**Recommendation Report for Listed Building Consent for Alterations, Extension or Demolition of a
Listed Building**

REF NO: AB/136/25/L

LOCATION: Houghton House
4 Arun Street
Arundel
BN18 9DL

PROPOSAL: Listed building consent for single storey rear extension, alterations to rear roof and internal alterations (resubmission following AB/26/25/L).

Proposed Ground Floor Plan 1:100

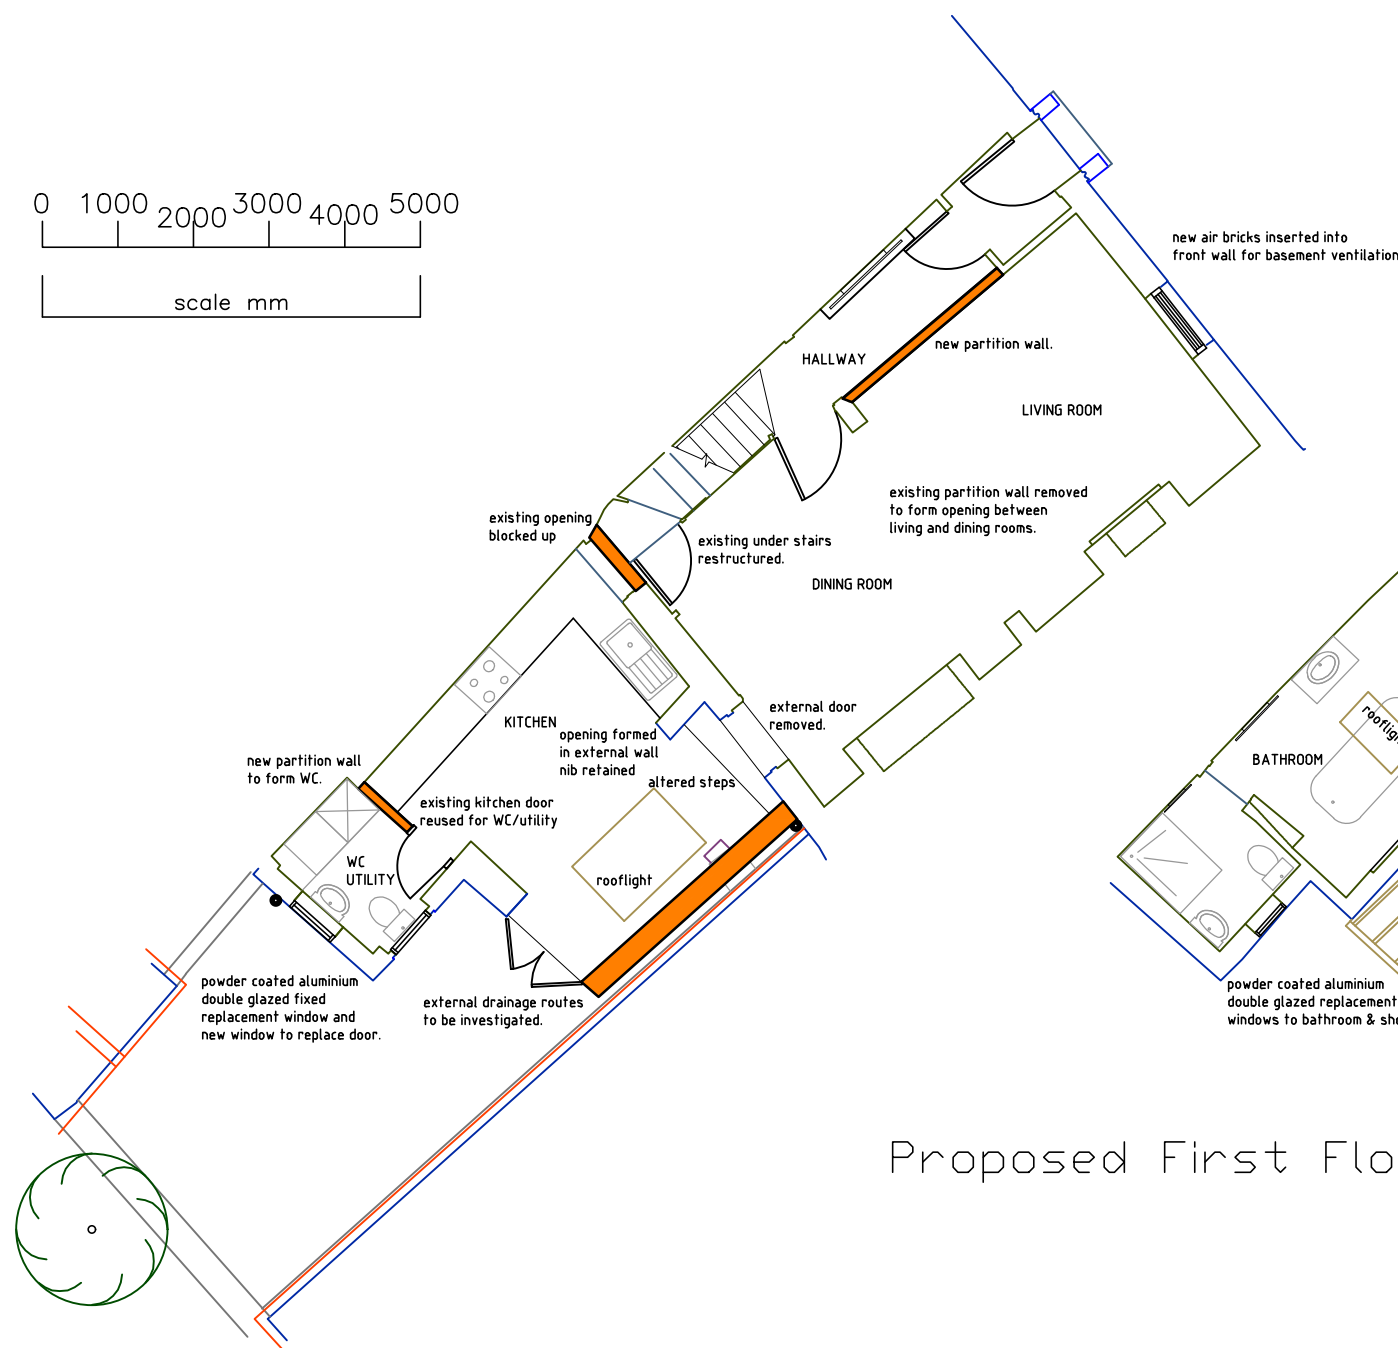
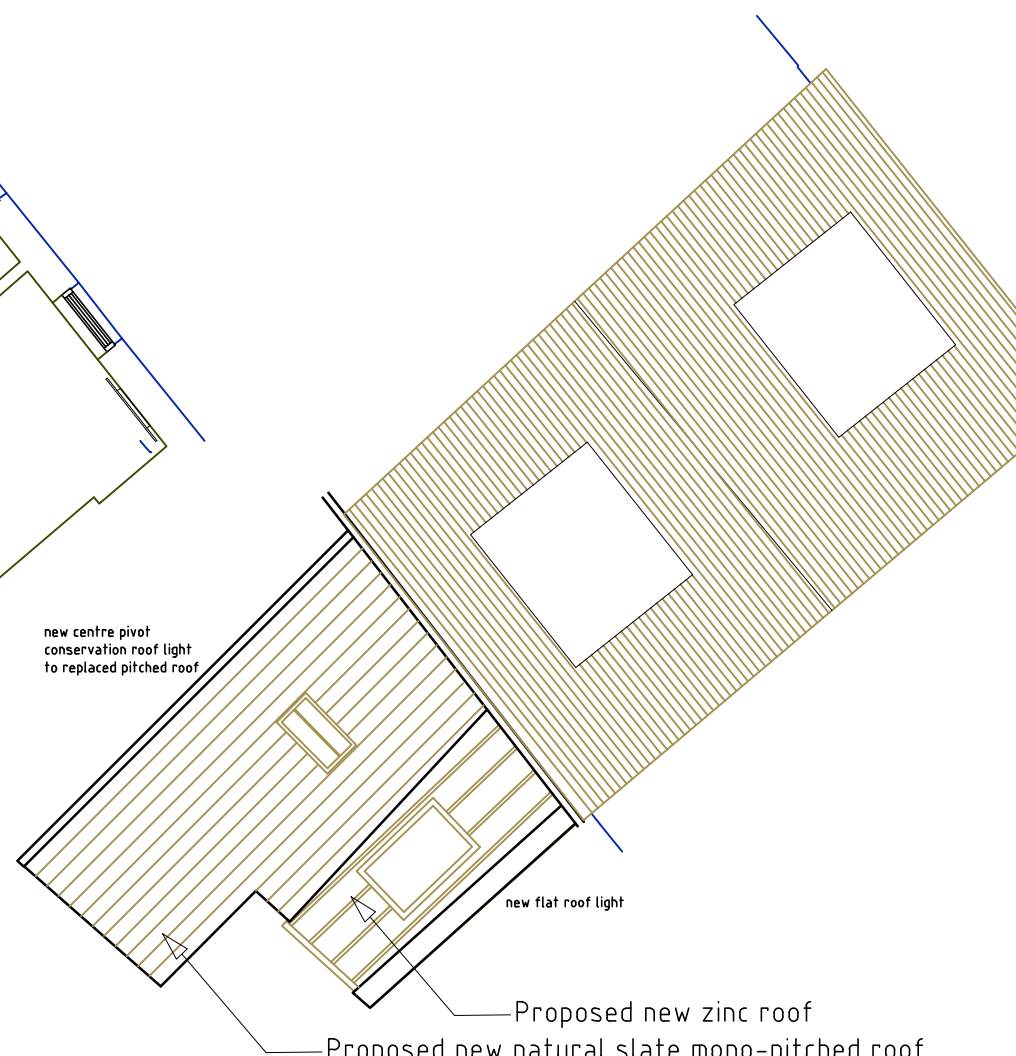
The extension design is well considered, featuring a simple roof form that respects existing features, along with a parapet wall with stone coping and rendered walls. The zinc roof with an inset rooflight is a positive element. The removal of external doors and part of the kitchen wall is noted, and the retention of wall nibs is welcomed as it preserves the legibility of the original layout.

I have reviewed the plans and note other works that appear acceptable. The existing basement cellar below the main living room has a serious damp problem. It is proposed to provide air bricks at low level to the front facade and replace/re-hang timber ceiling/floor joists to improve ventilation. The existing fabric here is modern and of no significance; this element is acceptable.

DRAWING
**PROPOSED
ELEVATIONS**

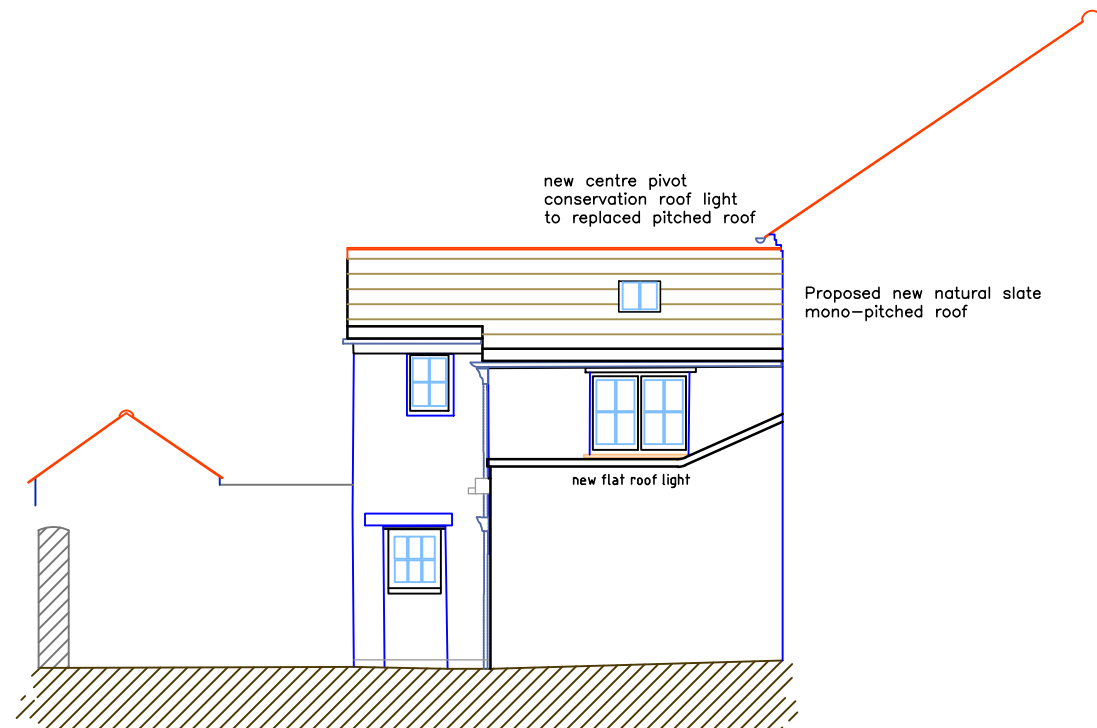
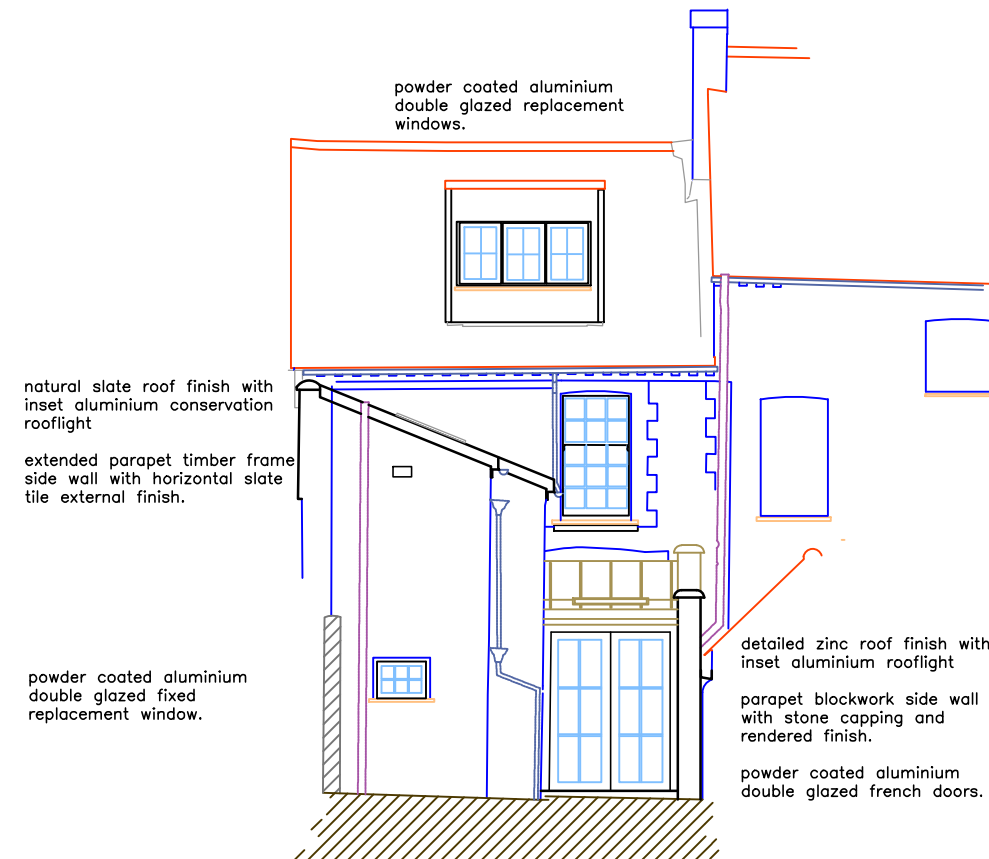
Conservation Area Advisory Committee - The proposals relate to the rear of the building and, as such, there will be no impact on the character or appearance of the conservation area. The Panel welcomed the overall improvement in the appearance of the fenestration but considered that, given the listed status of the building, painted timber windows, especially the sliding sash one at first floor level on the west elevation, would be more appropriate in this instance than the powder coated aluminium proposed.

The proposed revisions to the rear windows are acceptable in light of these specific circumstances. This decision does not set a precedent for other schemes within the town. However, it is not fully clear what the sash window will look like - there is no clear section detail, and it is unclear whether it will be a functioning sliding sash or a top-hung casement. The latter would not be acceptable in a listed building. Further information and clarification are required.

Comments noted. Further information has been received during the course of the application and the applicant has confirmed that the window on the rear elevation would be a functioning sliding sash. The Conservation Officer noted that a section drawing would have been preferable to the photo provided of the product, but has confirmed that the window is acceptable in this specific instance.
